DEVELOPMENT REVIEW BOARD--SPEED MEMO

DRB CASE NO/PROJECT NO: 1002072

**11. Project #1002072
Application # 02DRB-01012
Miramontes Park, Unit 1, Lots 2-A and 2-B, Block 8**

**15. Project #1002072
Application # 02DRB-01012
Miramontes Park, Unit 1**

Site Sketch
 Lots 2-A and 2-B, Block 8
Miramontes Park, Unit 1
 Albuquerque, Bernalillo County, New Mexico
 June 2002

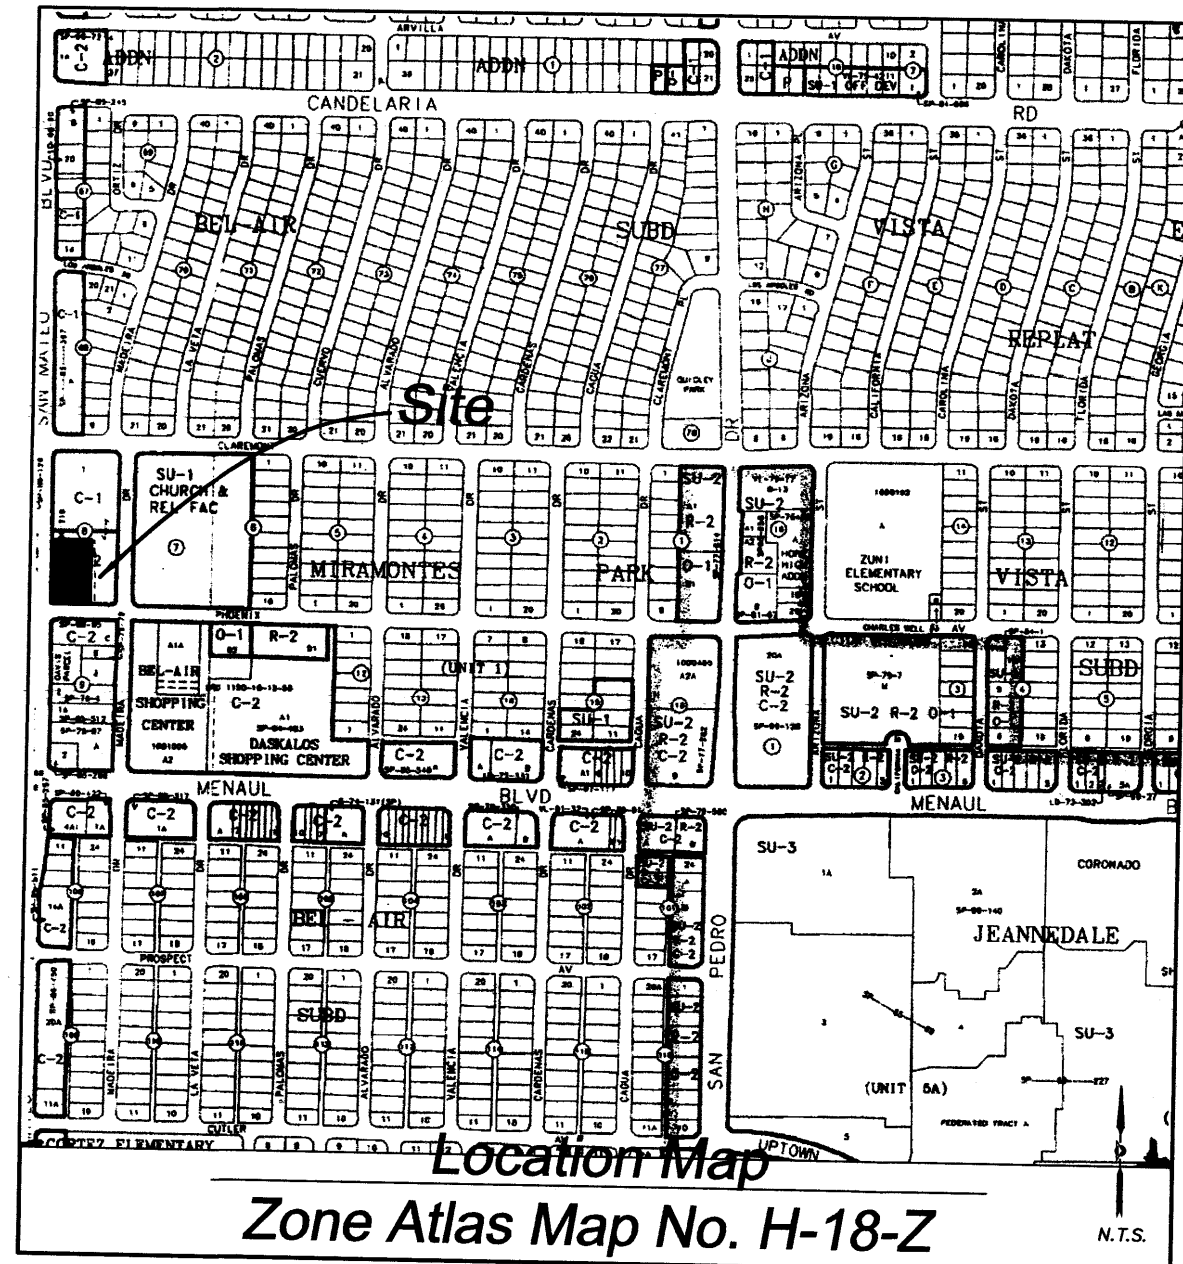
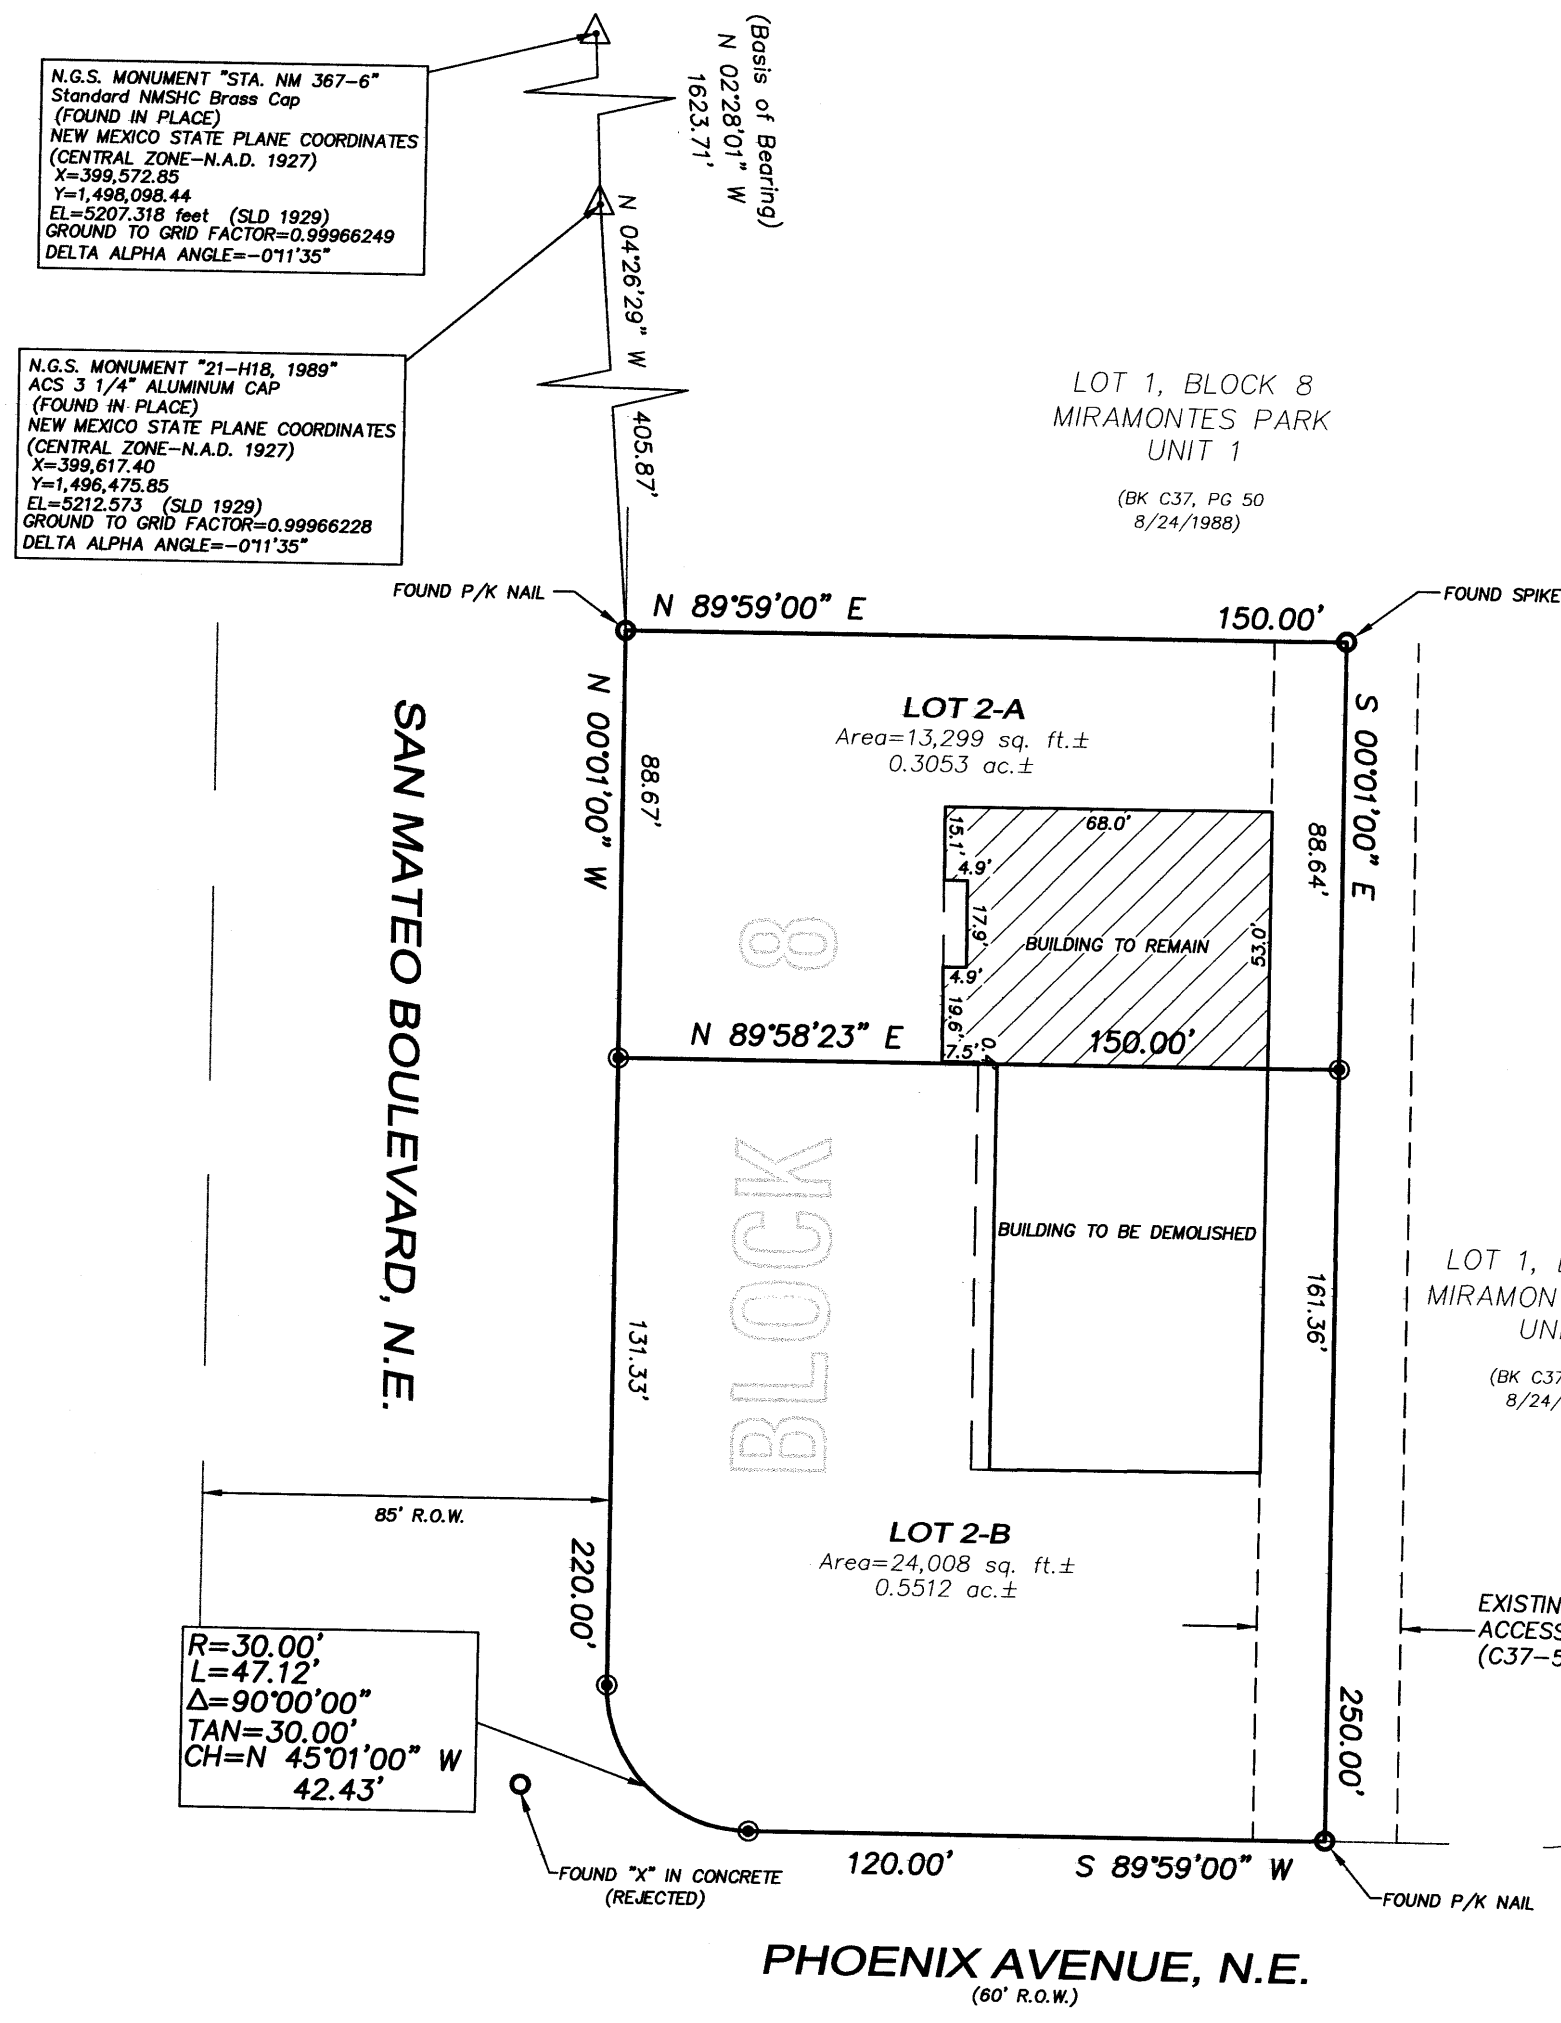
- Provide site sketch for proposed lots fronting San Mateo Blvd (in terms of sidewalk and curb & gutter location and setback). *(10' of Row from face of c&g to property line)*

Plat of
 Lots 2-A and 2-B, Block 8
Miramontes Park, Unit 1
 Albuquerque, Bernalillo County, New Mexico
 June 2002

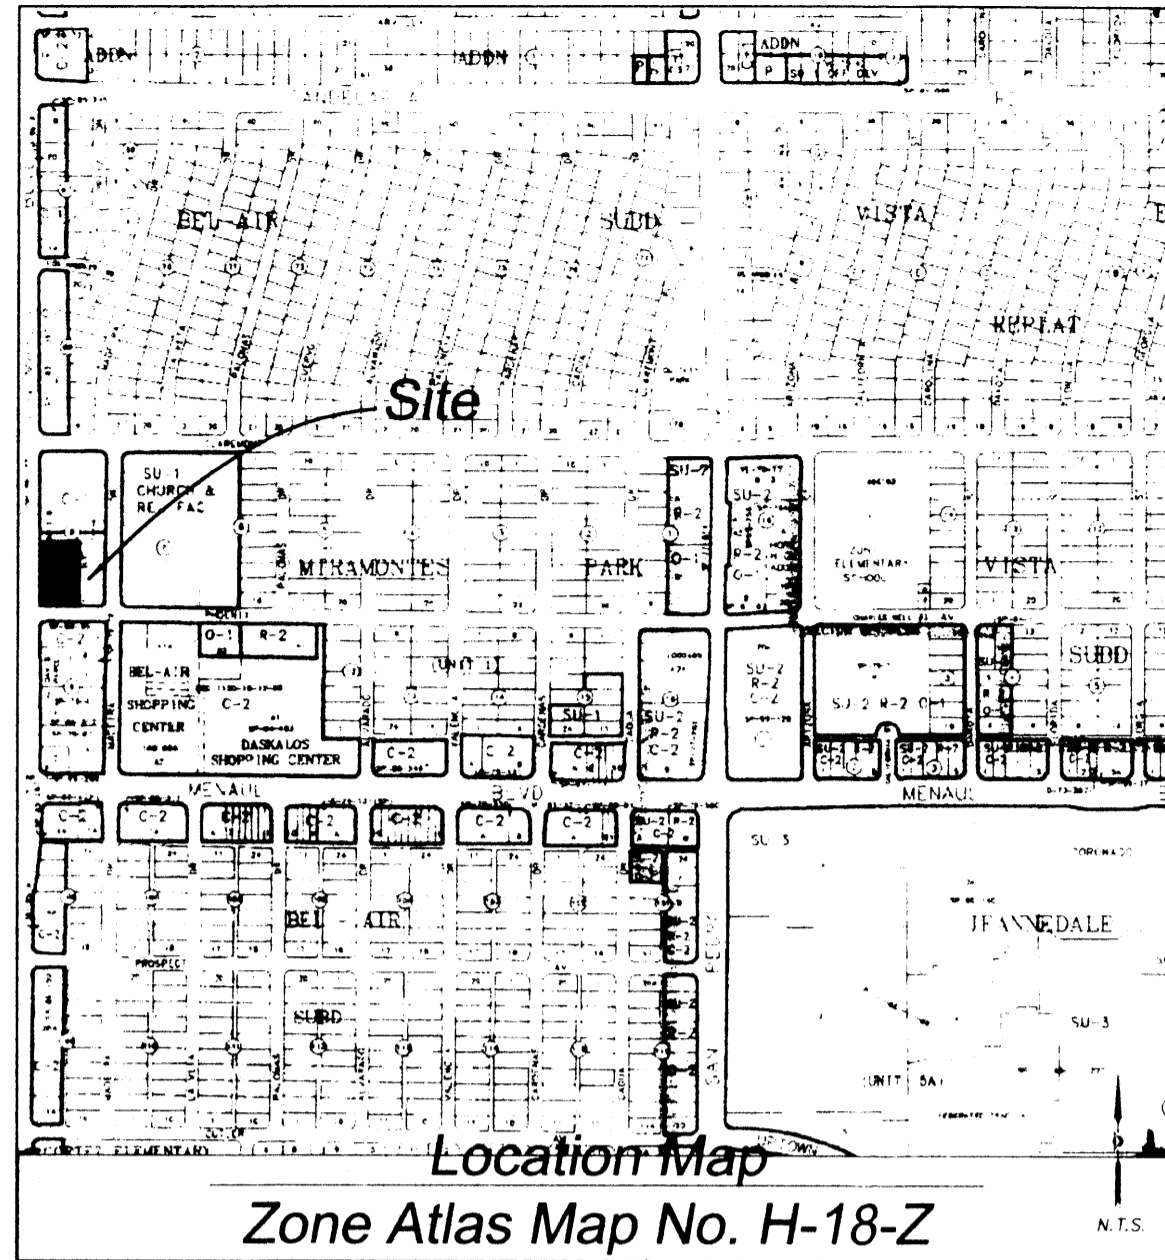
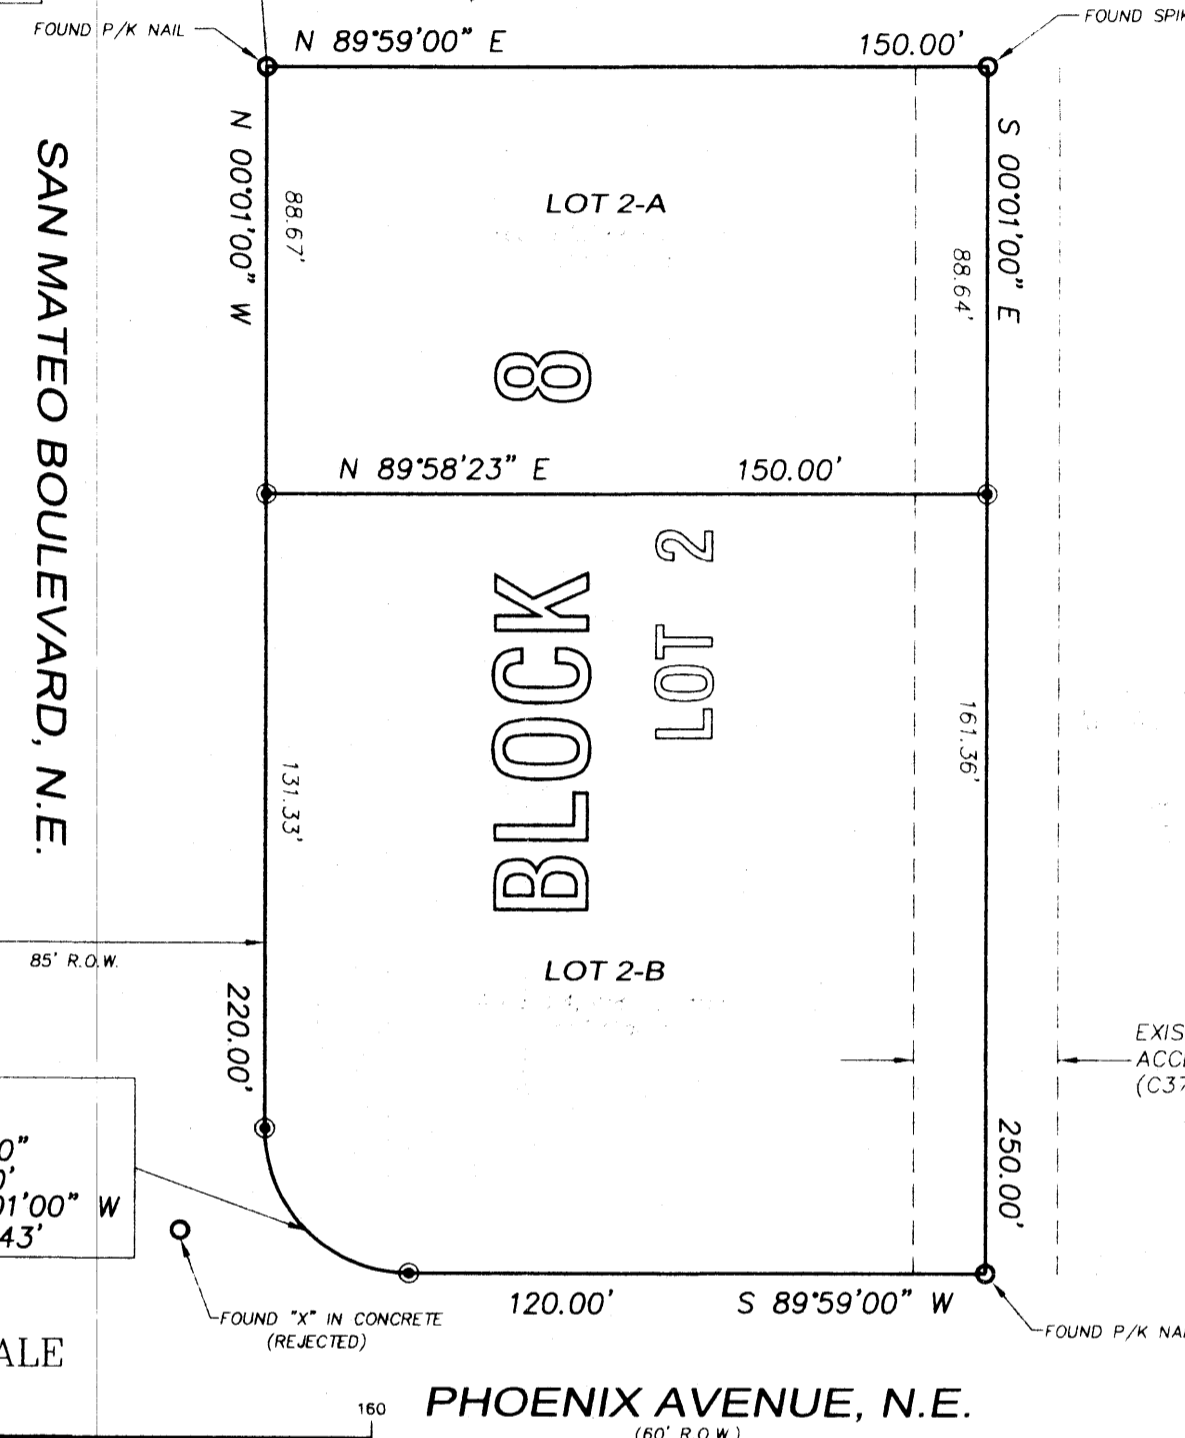
1. Include the Project # and Application # on the plat.
2. Refer to the Zoning Code regarding setback and height requirements. Confirm that the "building to remain" is in compliance.
3. Include the Project # and Application # on the plat.
4. Planning signs last. All other City and utility company signatures are required prior to requesting final sign-off by Planning.
5. Property Management's signature is required only on plats that vacate public right-of-way or dedicate parkland. Otherwise, the signature line may be marked "n/a".
6. Minor subdivision plats (if not completing a vacation) may be recorded by the applicant/agent. A copy of the recorded plat must be provided to Planning in order to close the case file.
7. Please provide a digital dxf file showing easement, parcel and right-of-way lines on the final plat in New Mexico State Plane Feet, NAD 1927.
